**From:** Contact Centre (CRM) <contact@ribblevalley.gov.uk>  
**Sent:** 25 October 2023 10:35  
**To:** Planning  
**Subject:** Planning Application Comments - 3/2023/0652 FS-Case-556950820

**Planning Application Reference No.:** 3/2023/0652

**Address of Development:** 5 Brookes Lane  
bb7 9rg

We have also taken some photos of our wall/fence:

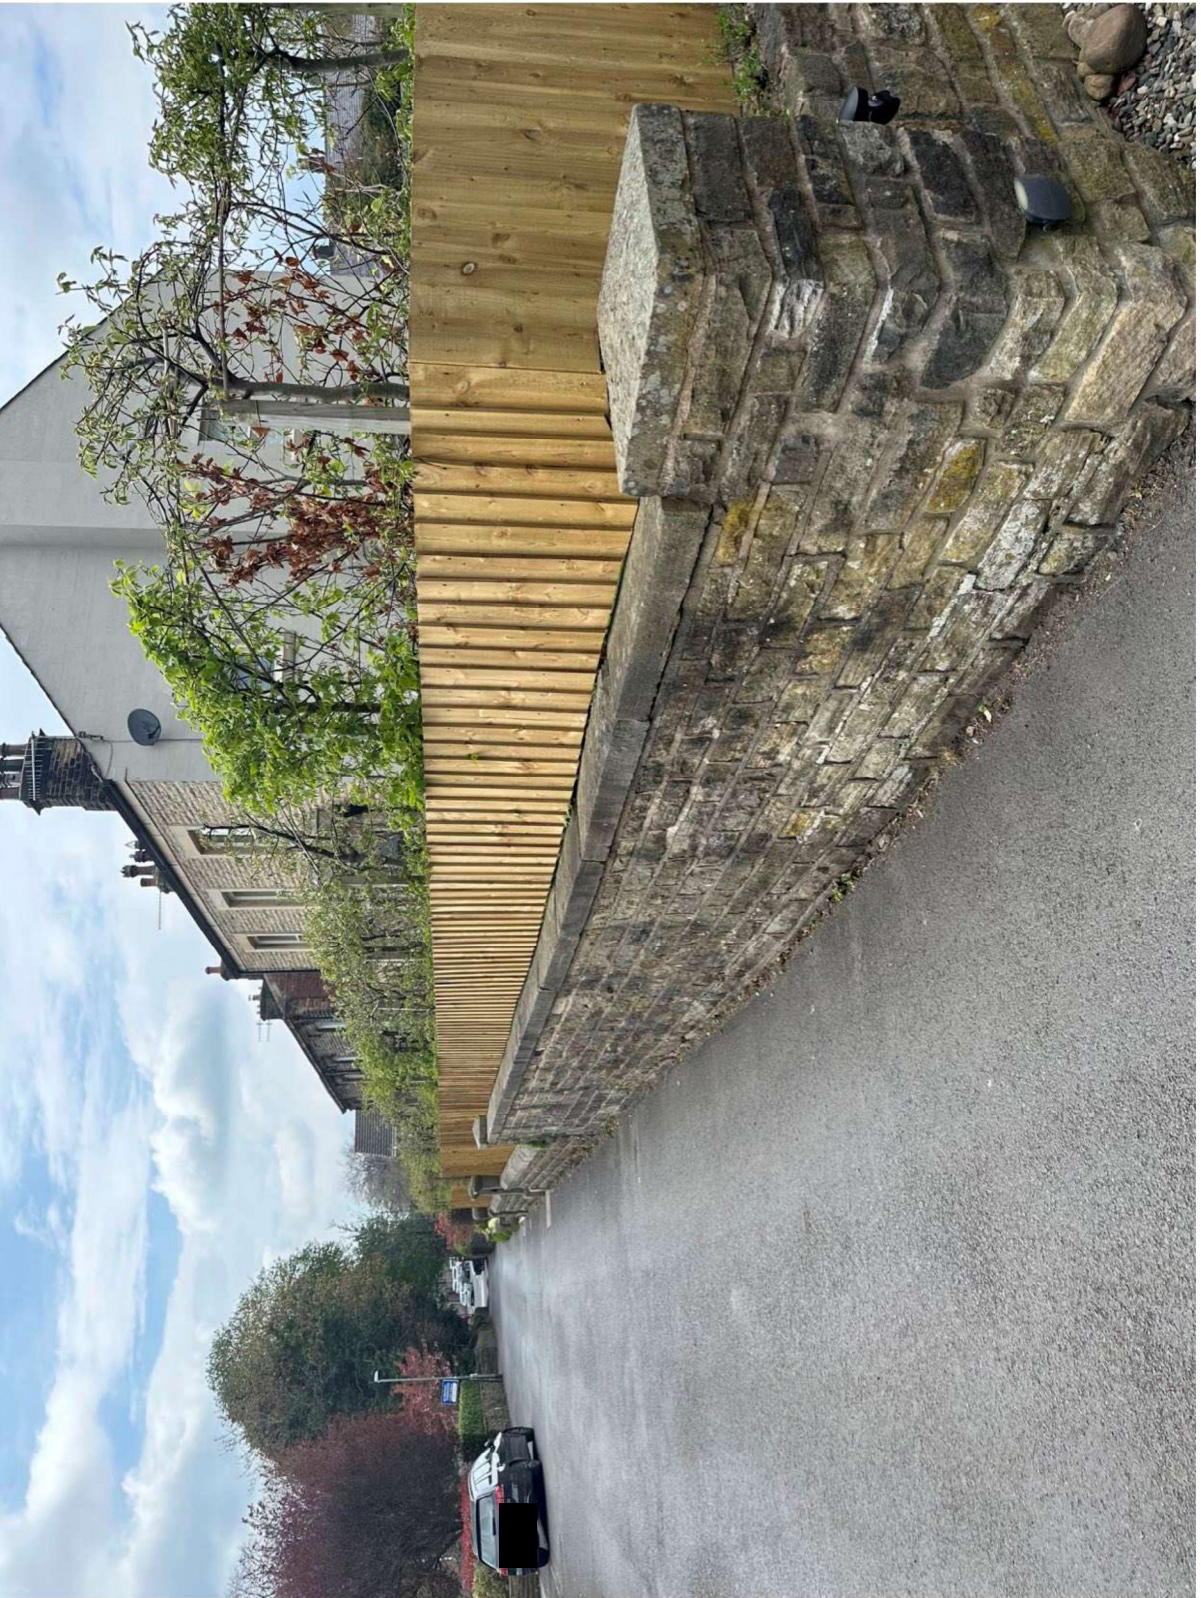
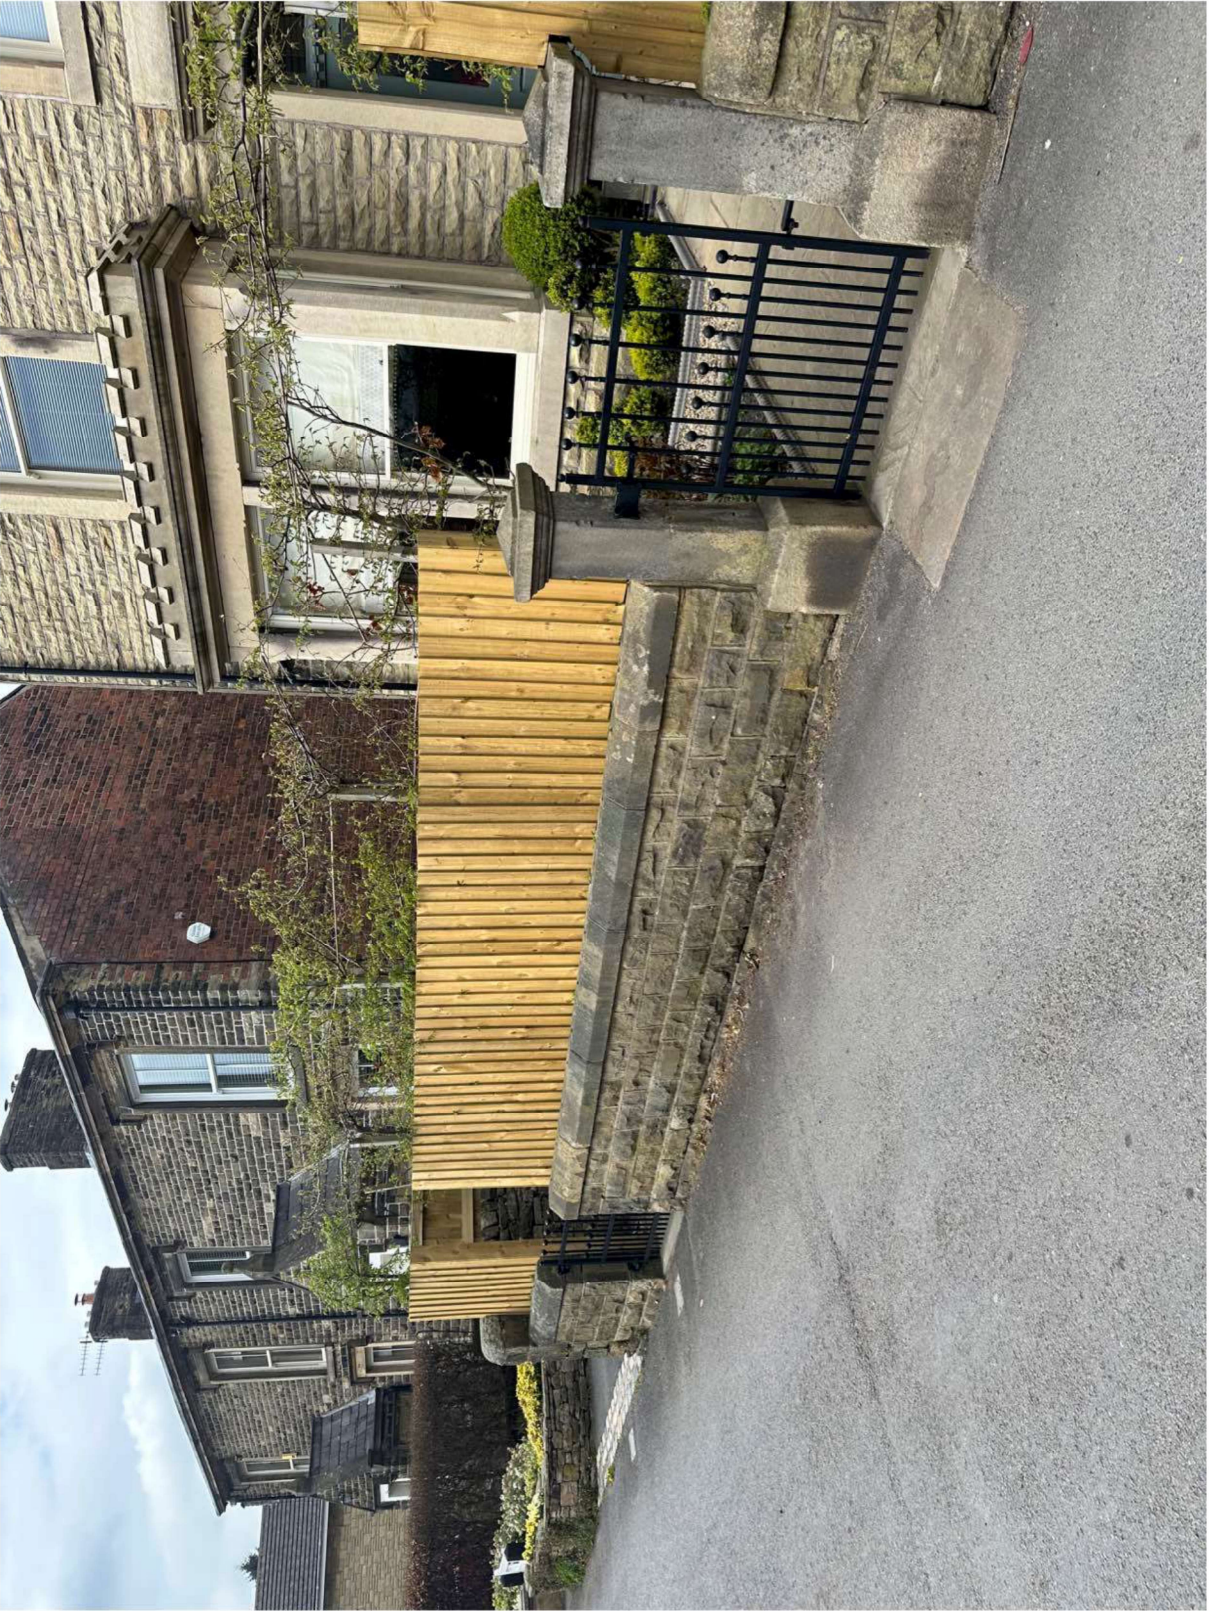
**Comments:** The fence creates 2 blind spots - 1 each for 3 and 5 Brookes Lane. Small children, therefore, cannot be seen by vehicles emerging from these properties. The lane is popular for access to the countryside - used by families and dog walkers. I always thought that fences joining a road/highway should be less than 1 metre for this purpose ?
